Hearing Transcript

Project:	Springwell Solar Farm
Hearing:	Issue Specific Hearing 3 (ISH3) - Part 4
Date:	16 July 2025

**TITLE:**  
FIGURE 3.3D  
GREEN INFRASTRUCTURE PARAMETERS  
SPRINGWELL WEST A

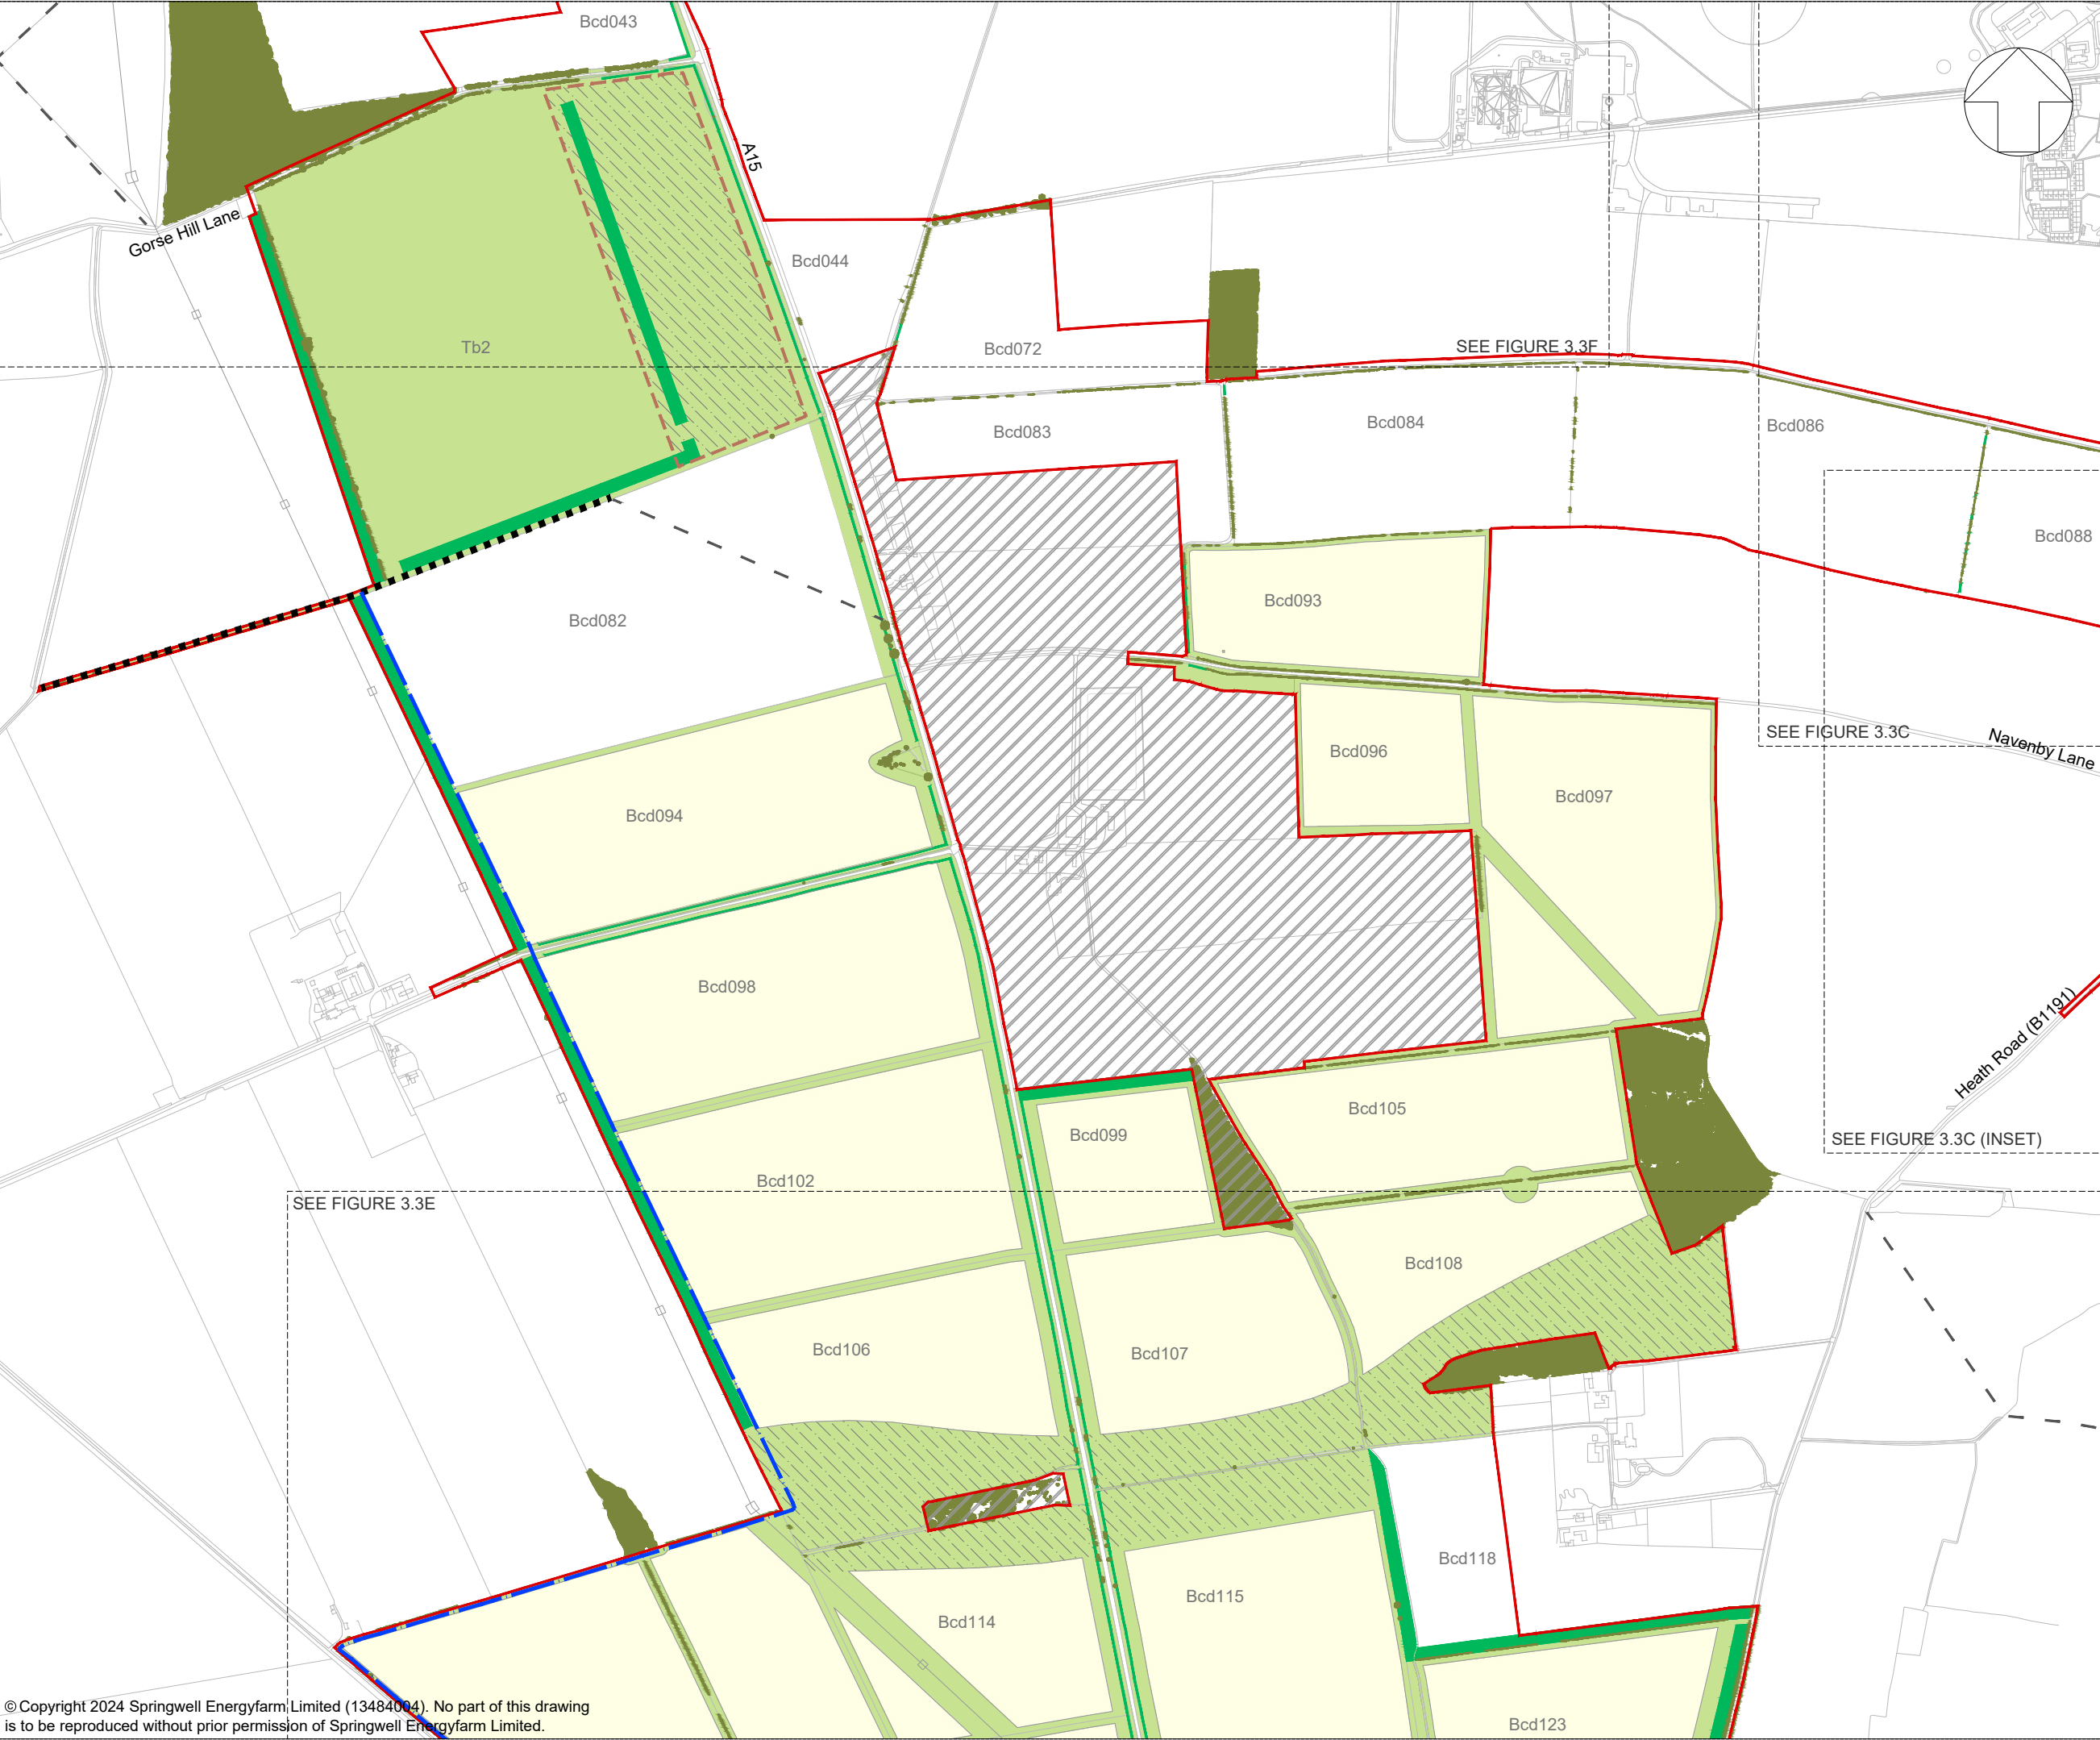
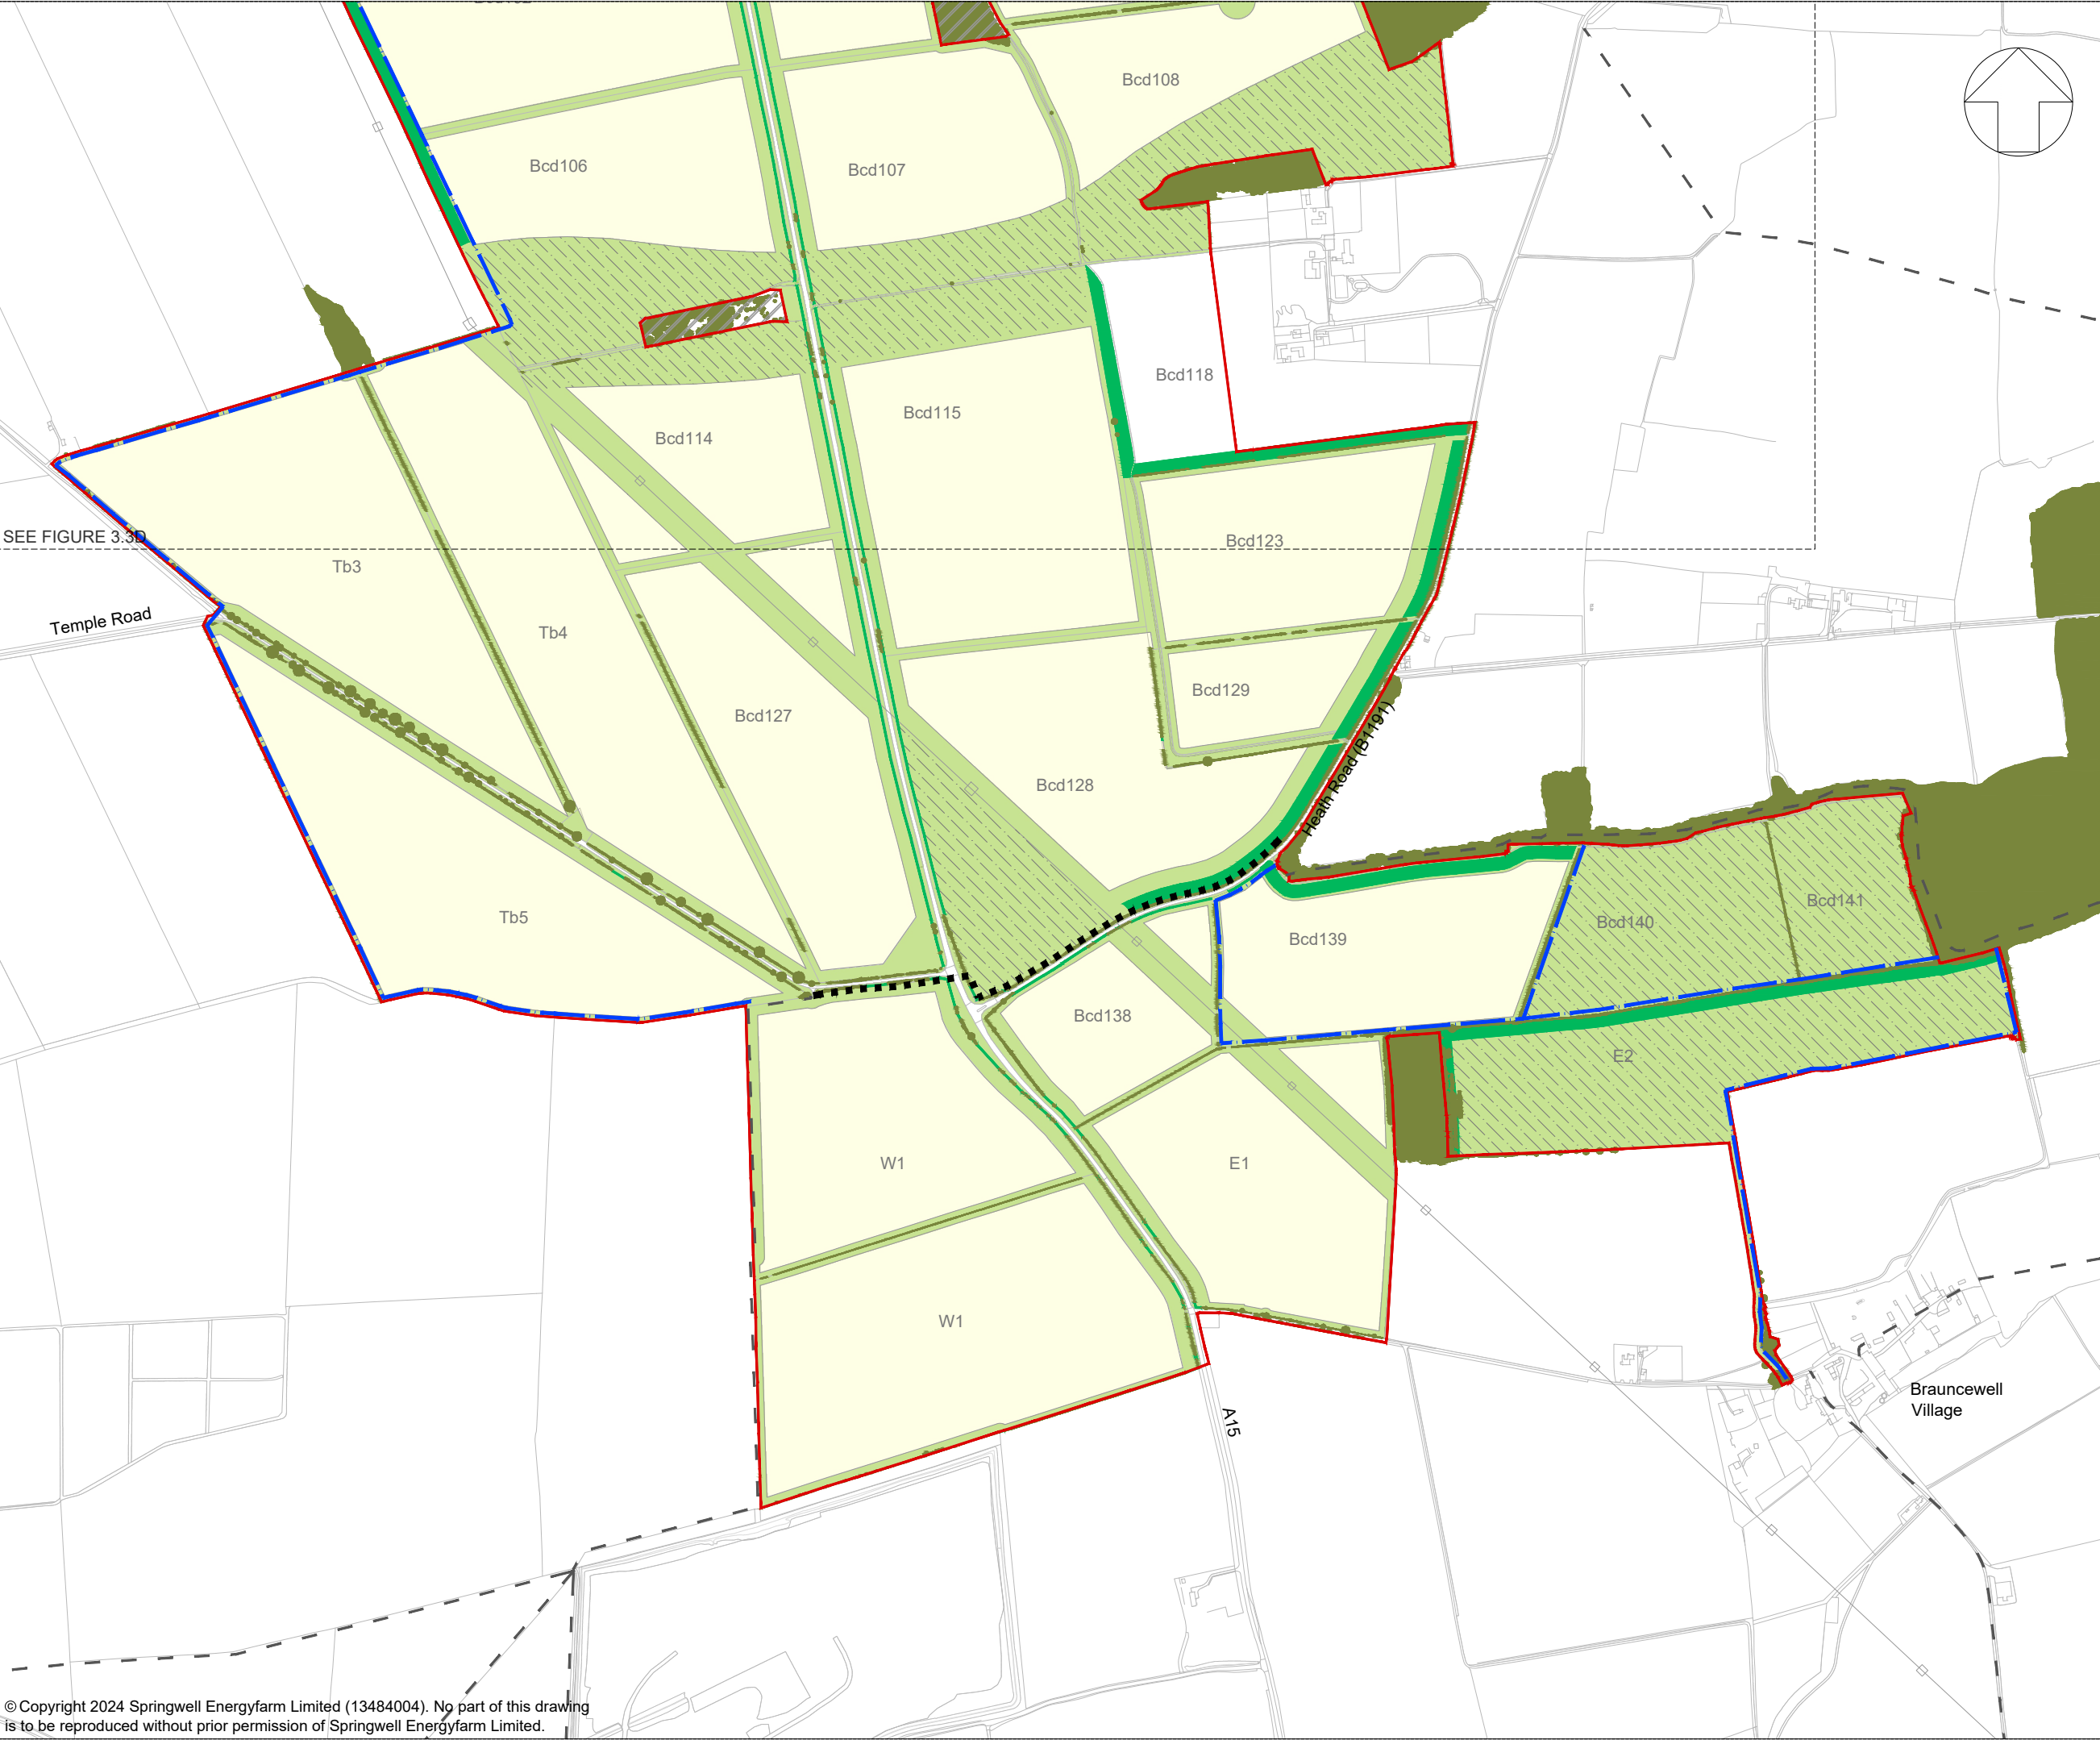
As a whole. So and if we look at the permissive parts as well, a large portion of the proposed permissive paths in Springfield Central and West, um, run right up against the solar panels without

visual screening proprieties. Um, and I appreciate that these are additional pathways that were not there before, but I can these be considered beneficial to health and wellbeing and.

Access for recreation if the experience is walking alongside the directly alongside the solar development.
